DECISION DELEGATED TO HEAD OF PLANNING

Application No:	H09-1089-21	Applicant:	Mr & Mrs C Parker
Proposal:	Alterations, Single Storey Extension and Garage		
Location:	52 Spalding Road Holbeach Spalding		
Terminal Date:	14th January 2022

Drawing.
PROPOSED
GROUND FLOOR PLAN - FIRST FLOOR PLAN

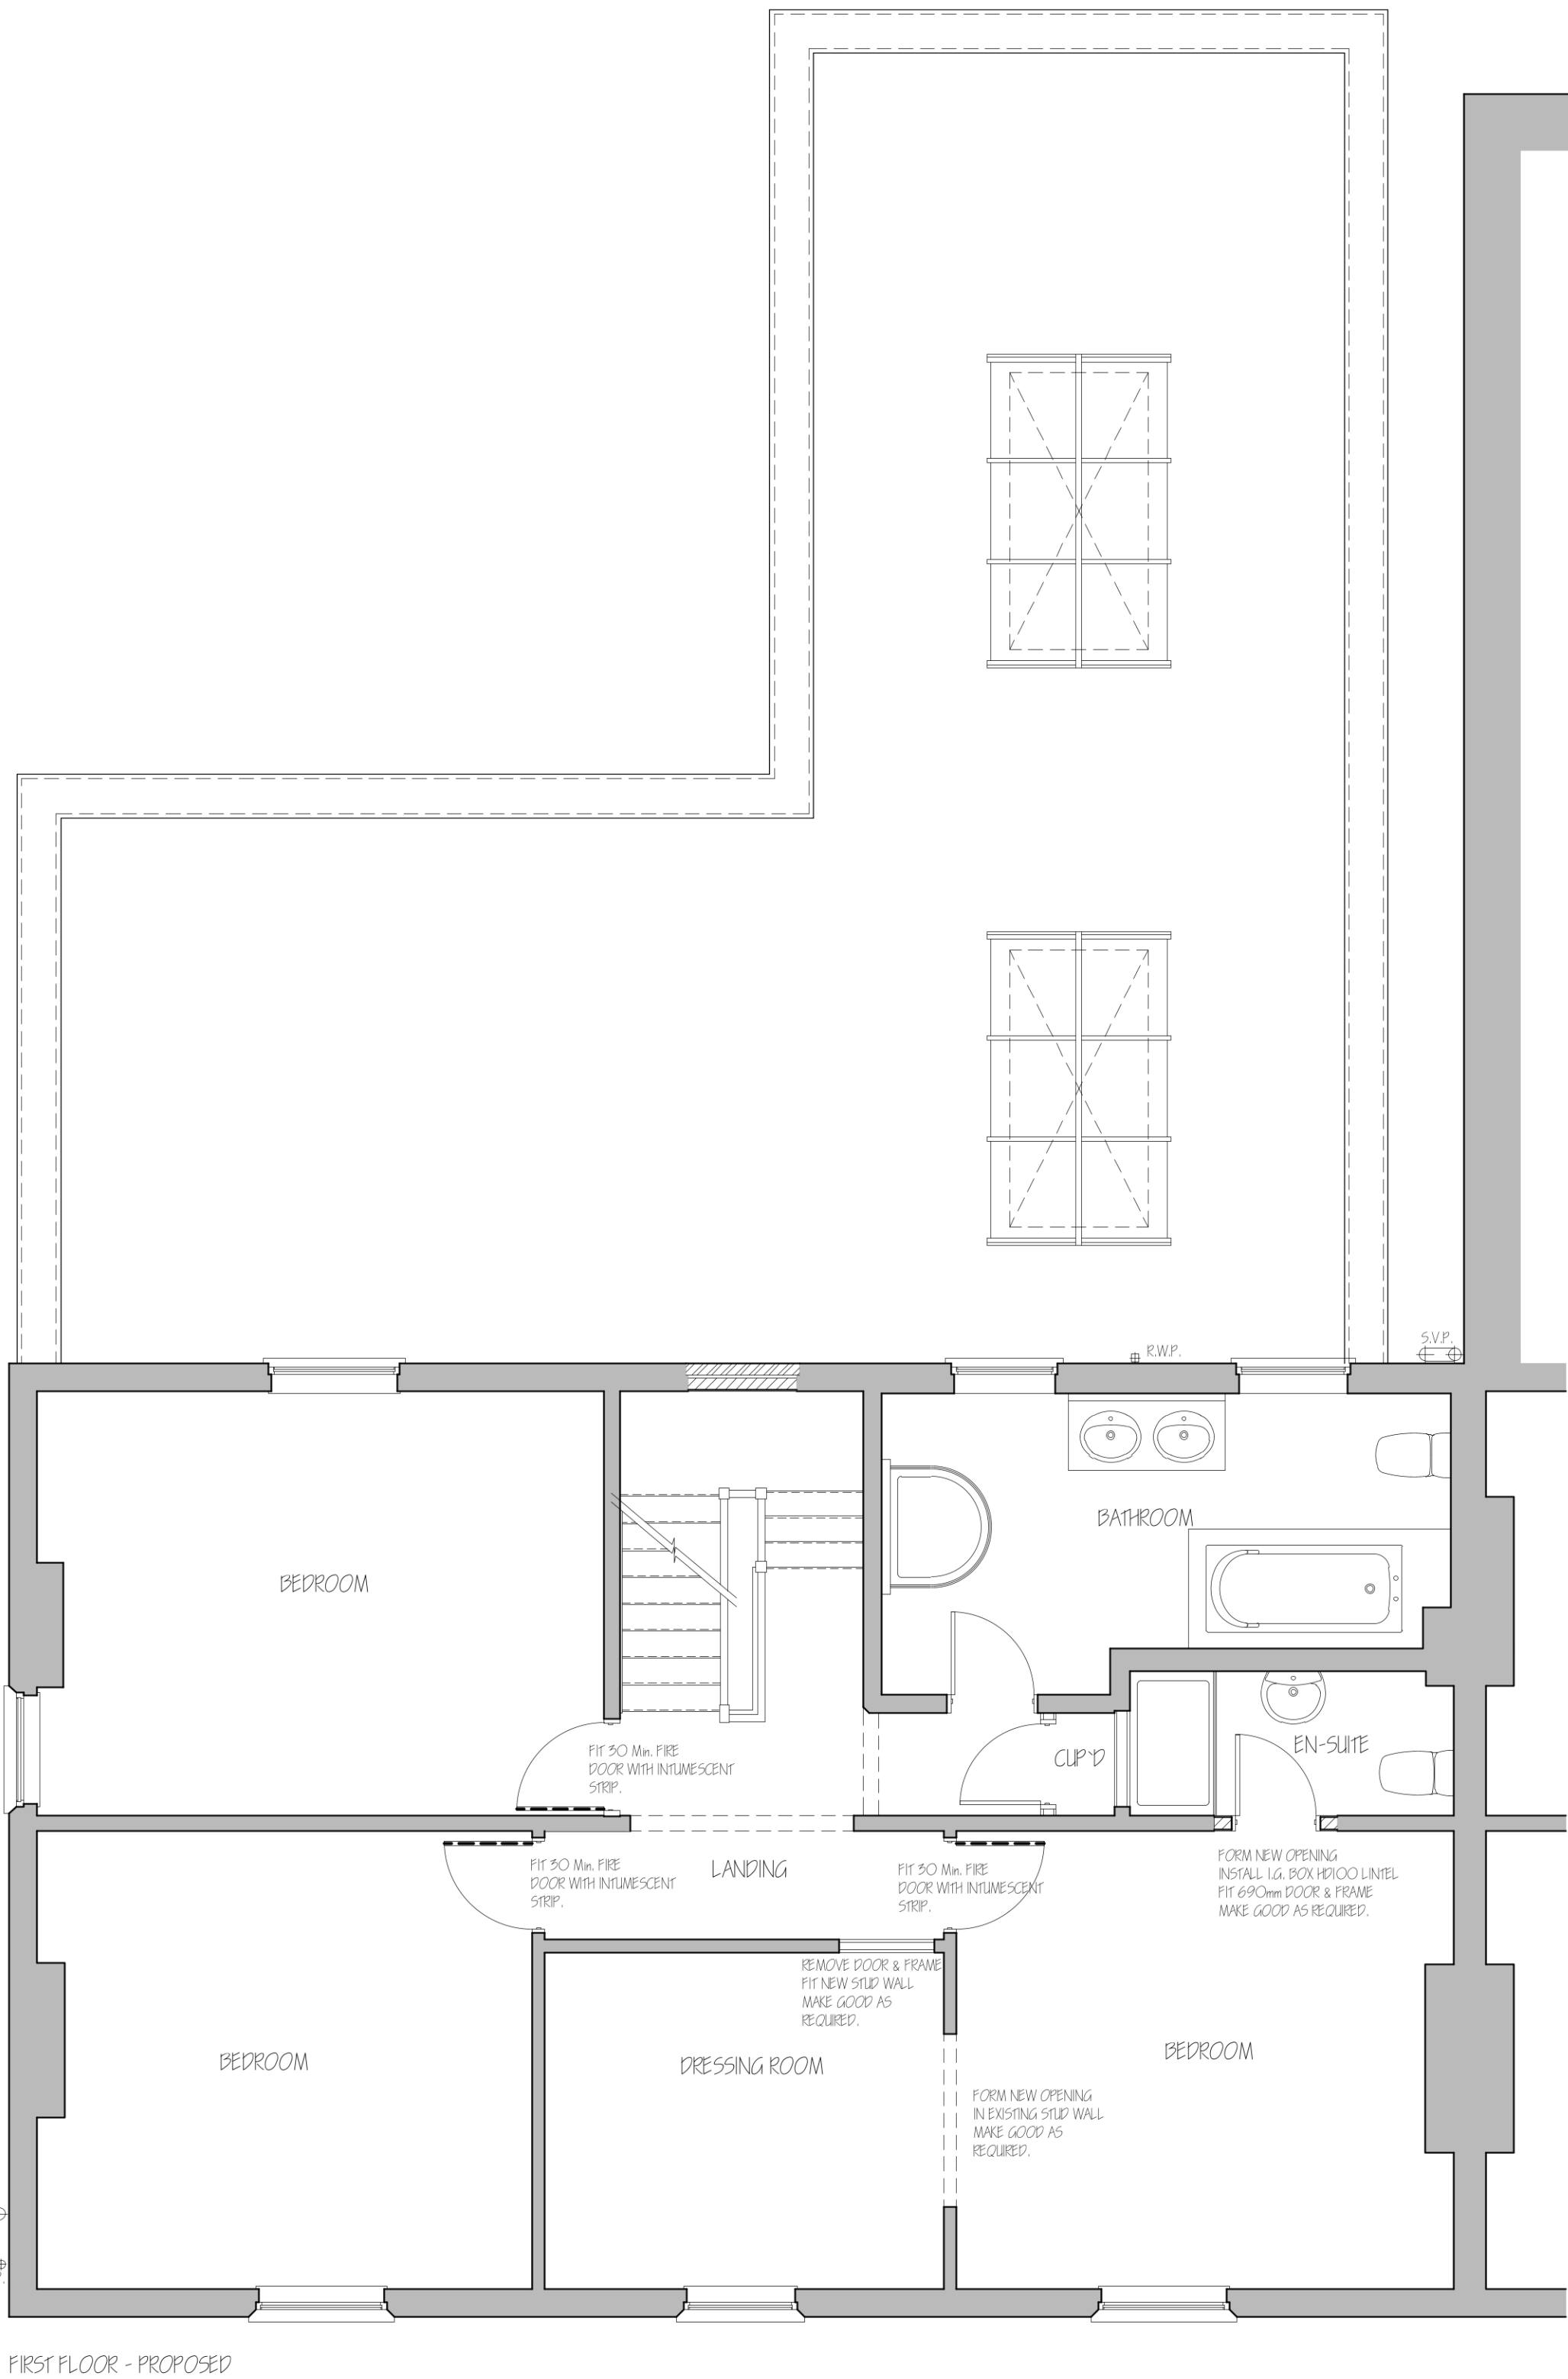
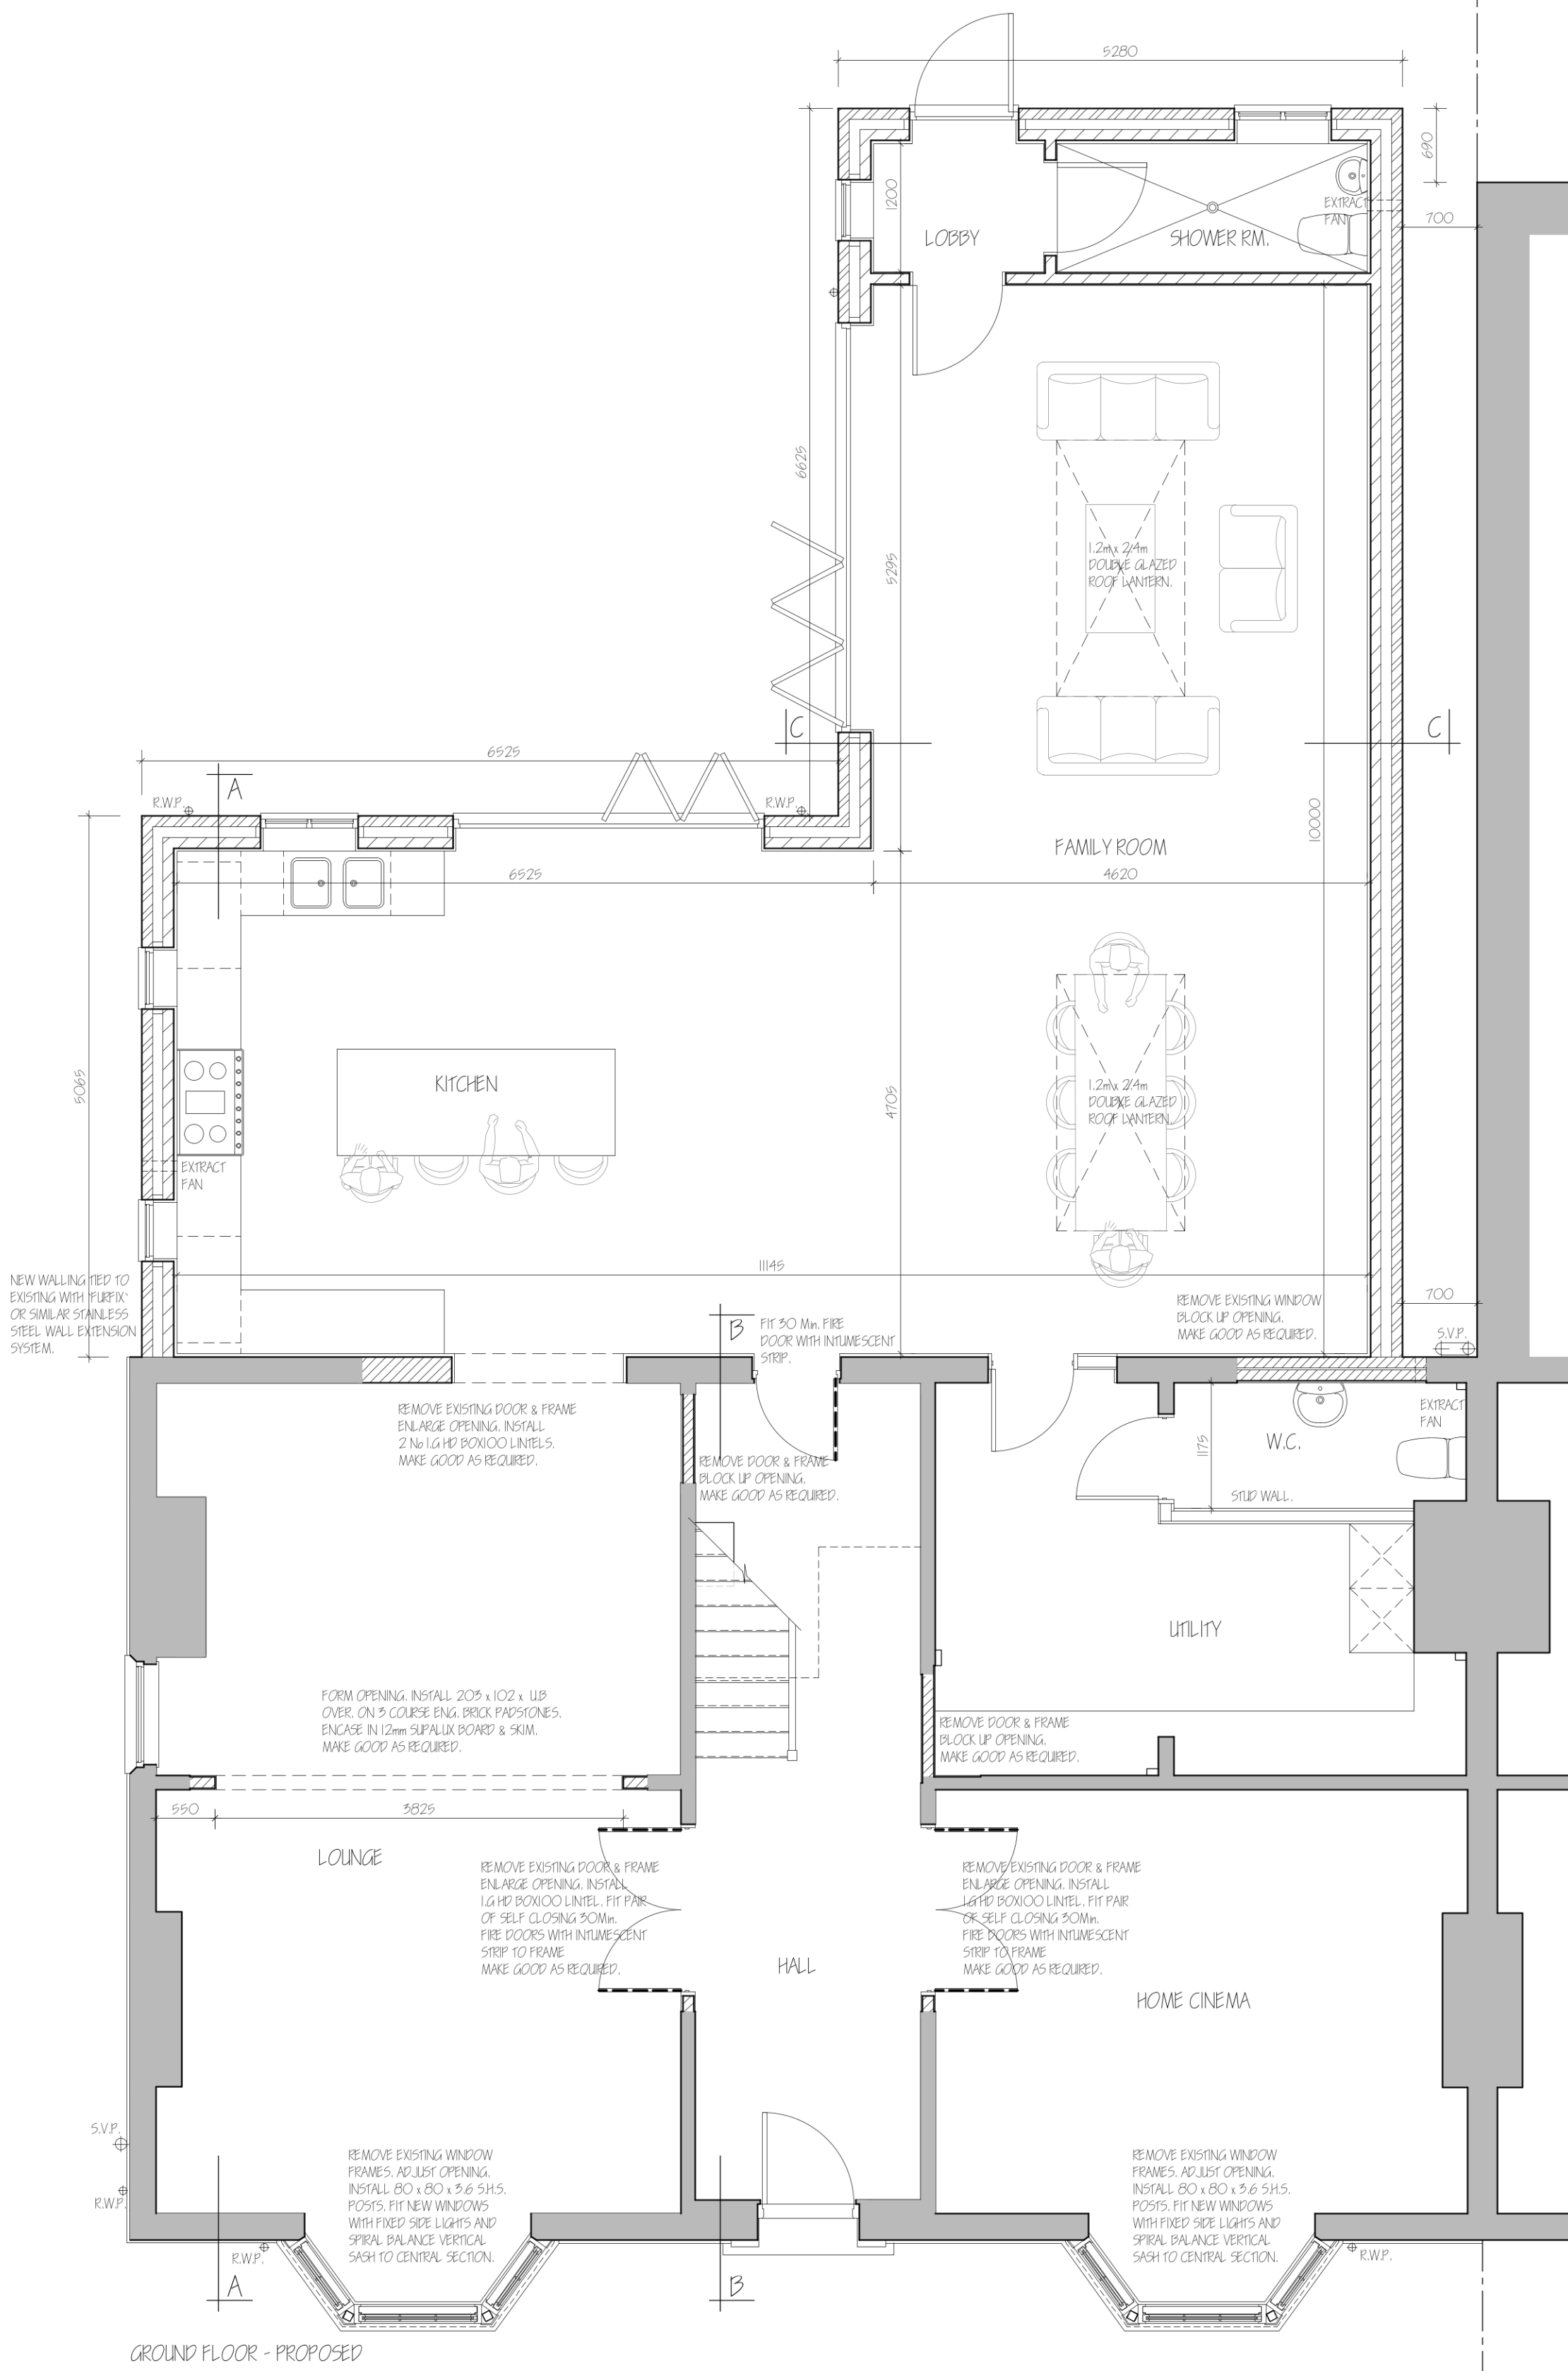
A local resident has objected to the proposal on grounds that it is not in keeping with the area given the depth of the rear extension. The concerns are noted and the depth of the rear extension has been reduced by 5.2 metres. The amended scheme is considered to be a lot more proportionate to the existing dwelling and the site.

The closest neighbour to the proposed development is the attached neighbour at no.50 Spalding Road. The proposed house extension would have a similar rear projection to this neighbour's existing rear projecting element along the shared boundary with the application site. As such the majority of the proposed development would not be visible to this neighbour. The proposed garage would also offer limited views given the presence of the high boundary hedge. As such the impact on this neighbour is considered to be within acceptable tolerances.

It should be noted that the application has been revised and the depth of the rear extension reduced by 5.2 metres.
